From:
Sent: 04 June 2026 16:04
To: DC Admin
Subject: planning application 2026 909???at 60 Cowrakes Rd HD3 3ST

We sent four comments to you yesterday. We would like to add one more concerning the listed status of all four cottages. It concerns the proposed demolition of the front garden wall of number 60 in order to provide a car parking space. This would significantly detract from the uniform appearance of this short row all of which have a front garden terminated by a stone wall providing access to the footpath.

Ground Floor Plan
1 : 50

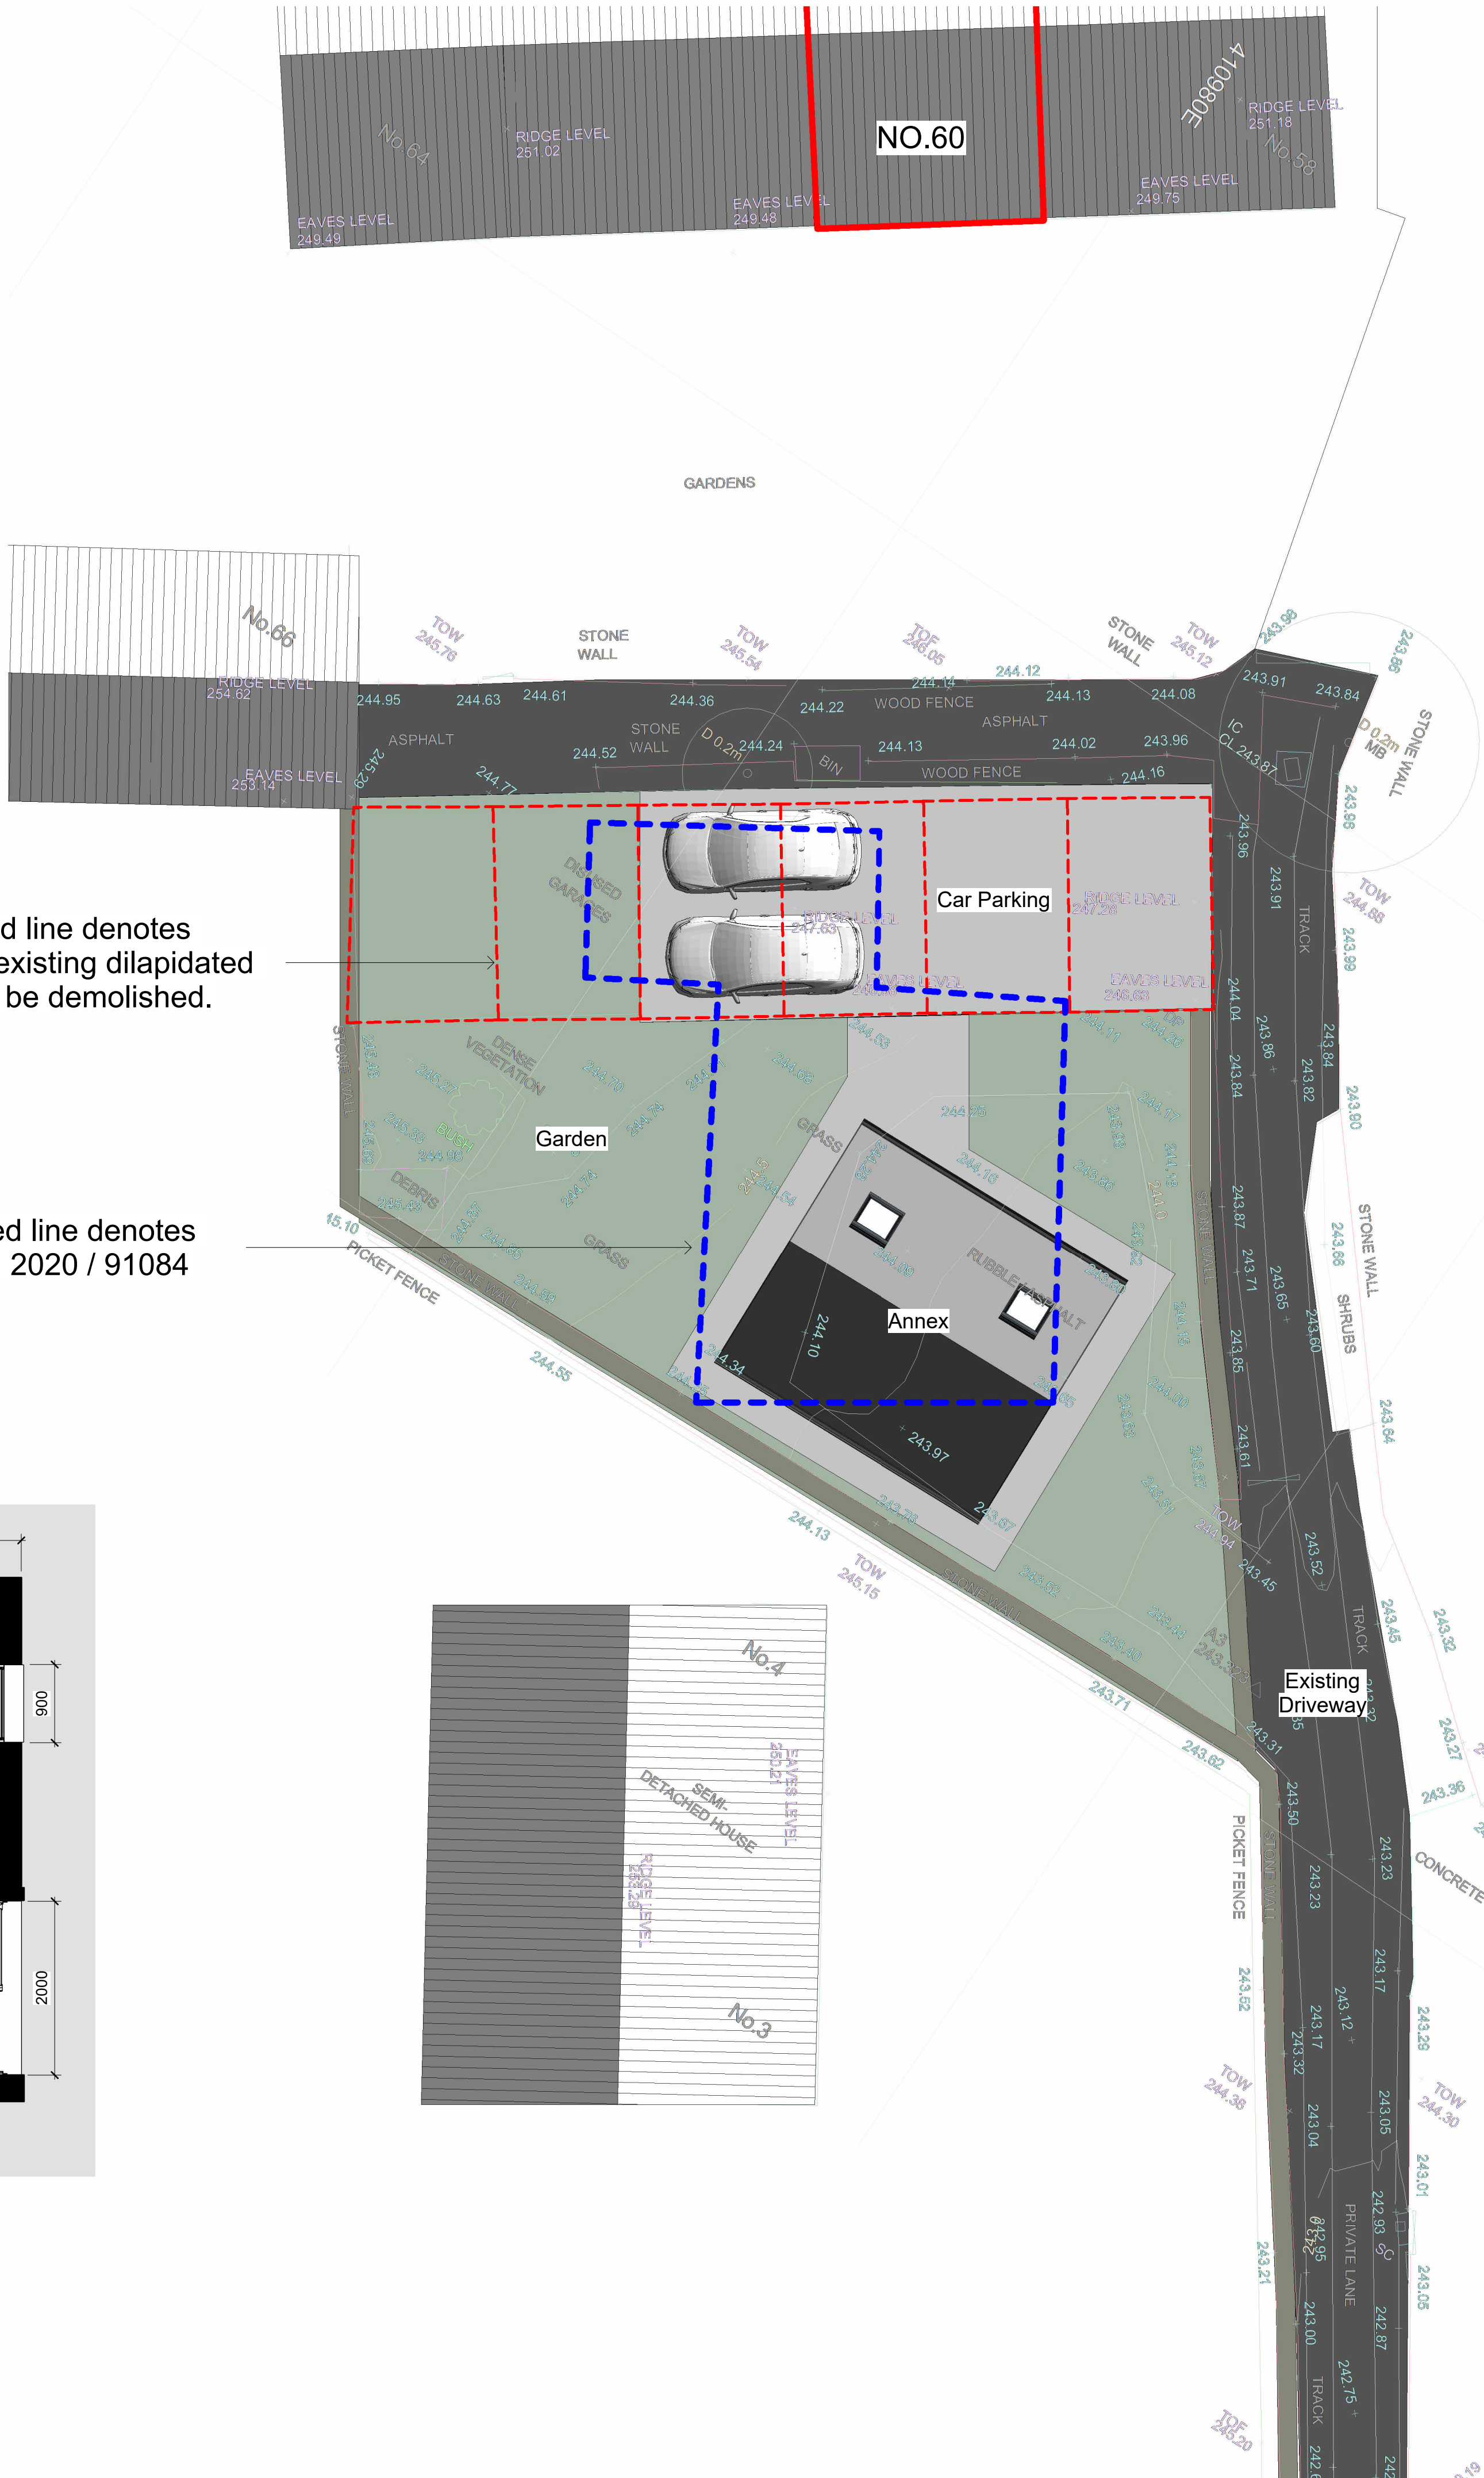
I telephoned planning this morning to ask for the Listed Building team in relation to this part of the plan as shown in the drawing of the annex and proposed parking of cars. They said the call-back system would over run the end date for comments, Saturday 6th June, hence this email now.
